Address: 65 Berkeley St

Permit # 2015-01503

CHECK-LIST AGAINST ZONING ORDINANCE

Proposed Use/Work - demolish 20'x30' existing section & add a one story 22.5' x 17.33' addition & a two story 45' x 22' addition w/ new driveway

1 Site Plan
SCALE: 1/16" = 1'-0"

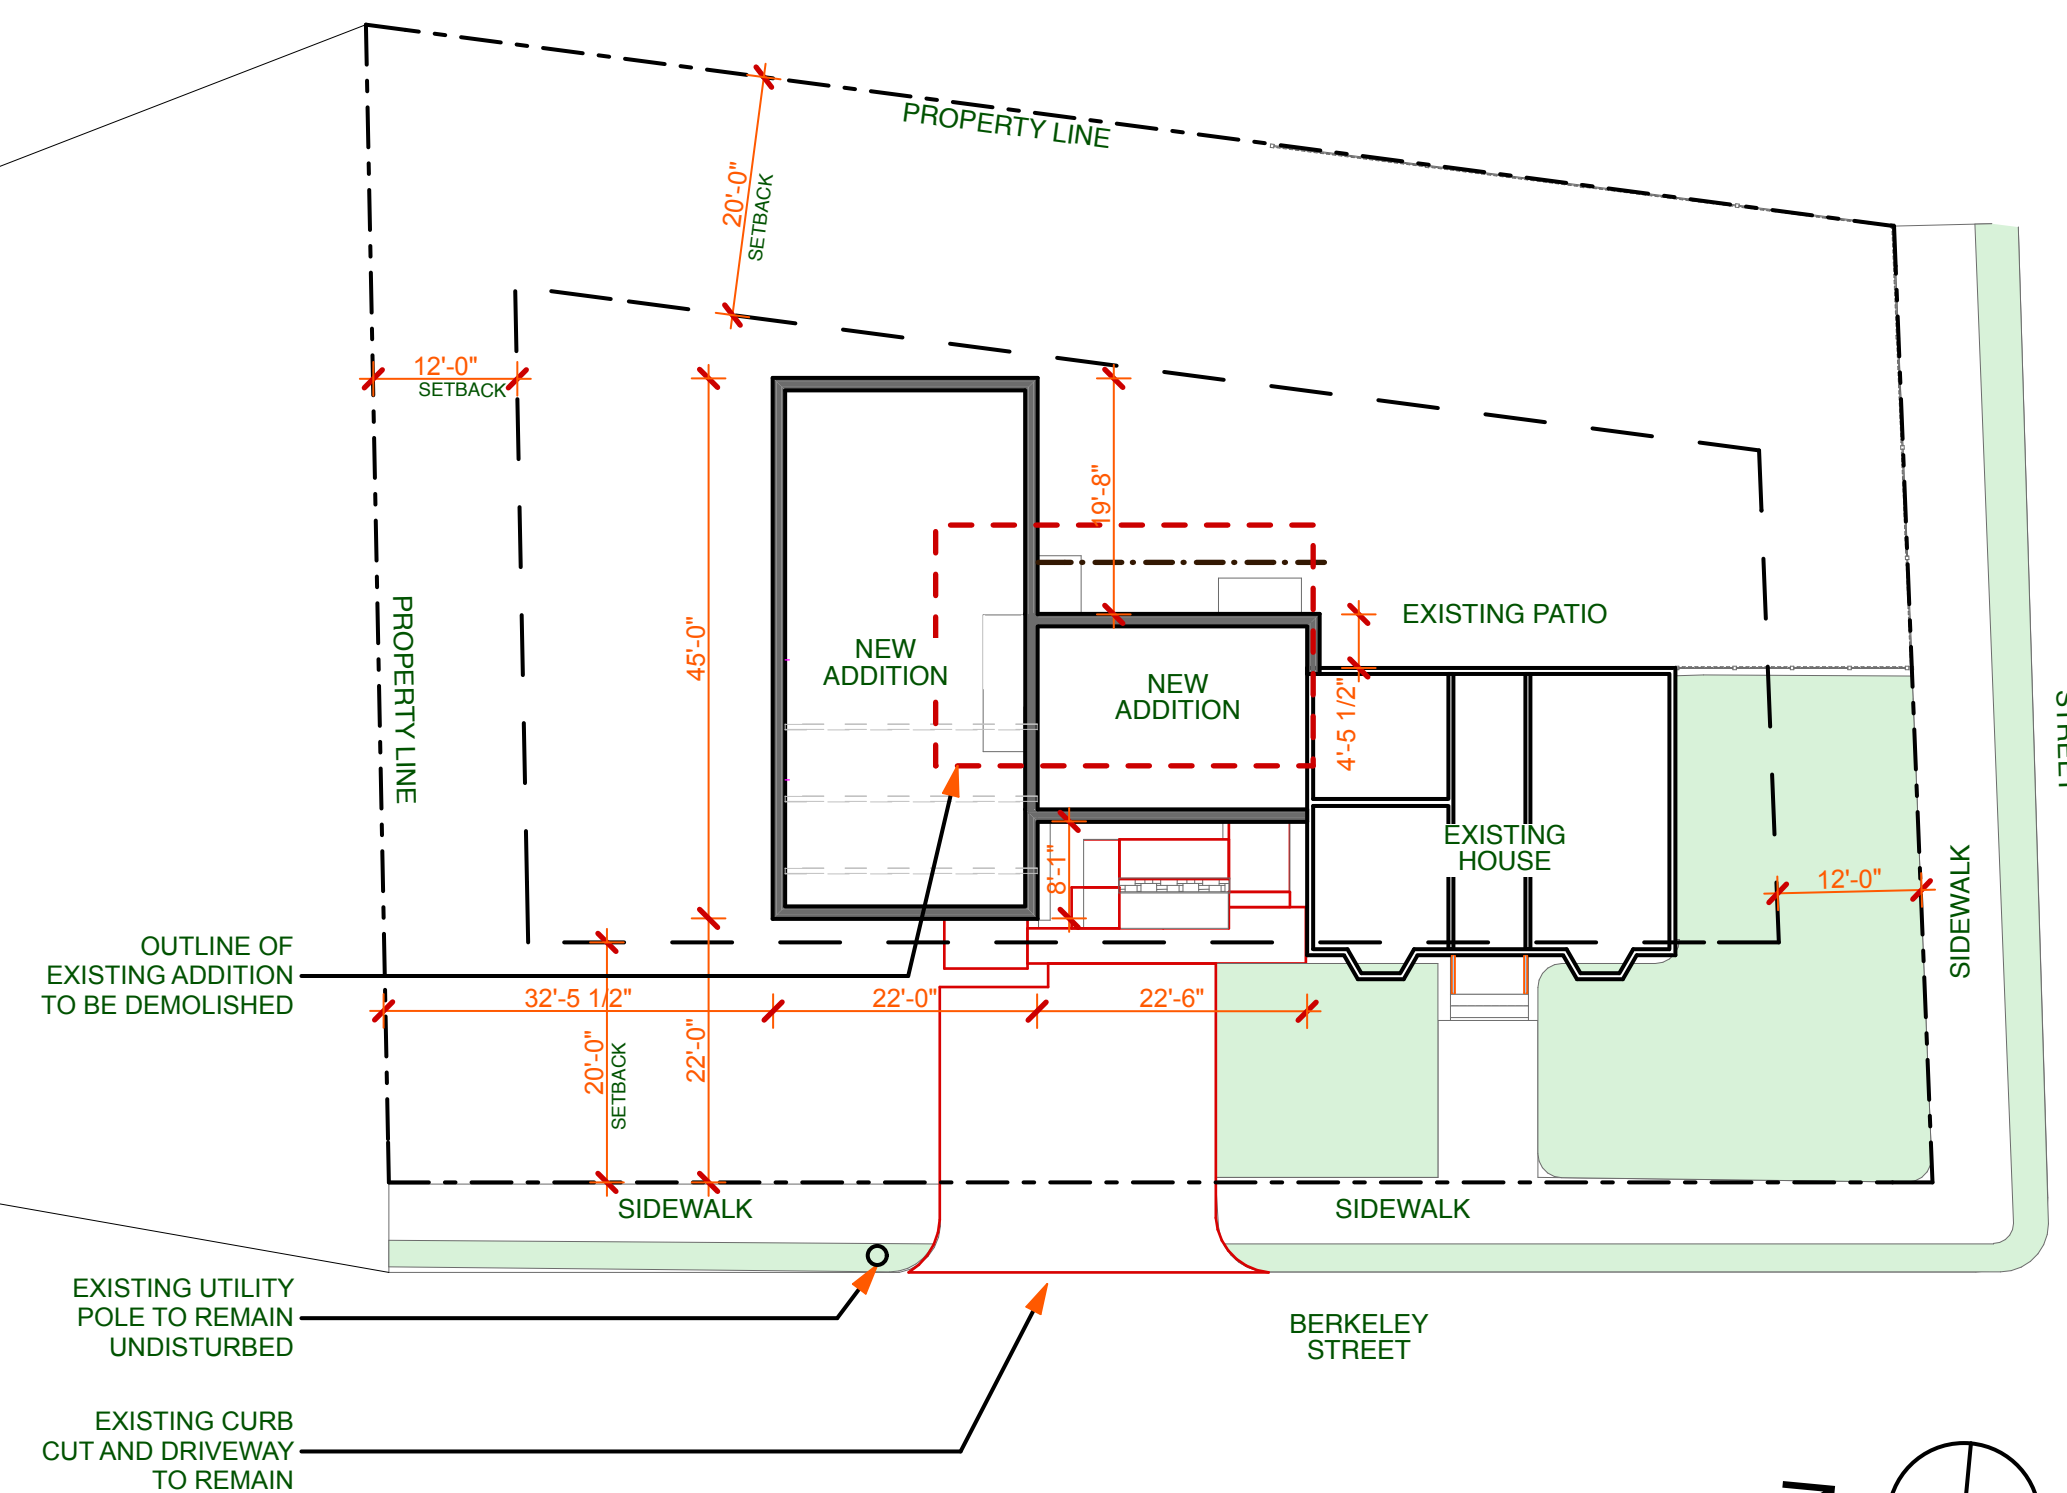
Front Yard - 20' min - 22' to edge of addition
- 4x7 - entry roof - 28' meets section 14-425 - 17.9 to porch (OK)

Rear Yard - 20' min - 22' scaled to rear of addition (OK)

Side Yard - 2 stories - 10' min - 32.5' scaled - OK

Height - 35' max - 24.5' from ridge (OK)

Lot Area - 6,000 sq ft min - 11,619 sq ft given (OK)

Lot Coverage Impervious Surface - 40% = 4,647.6 sq ft

Off-street Parking - need two parking spaces - two spaces existing.

addition - 22.5 x 17.33 = 389.9 sq ft

- 24 x 45 = 1080

2,272.9 sq ft OK
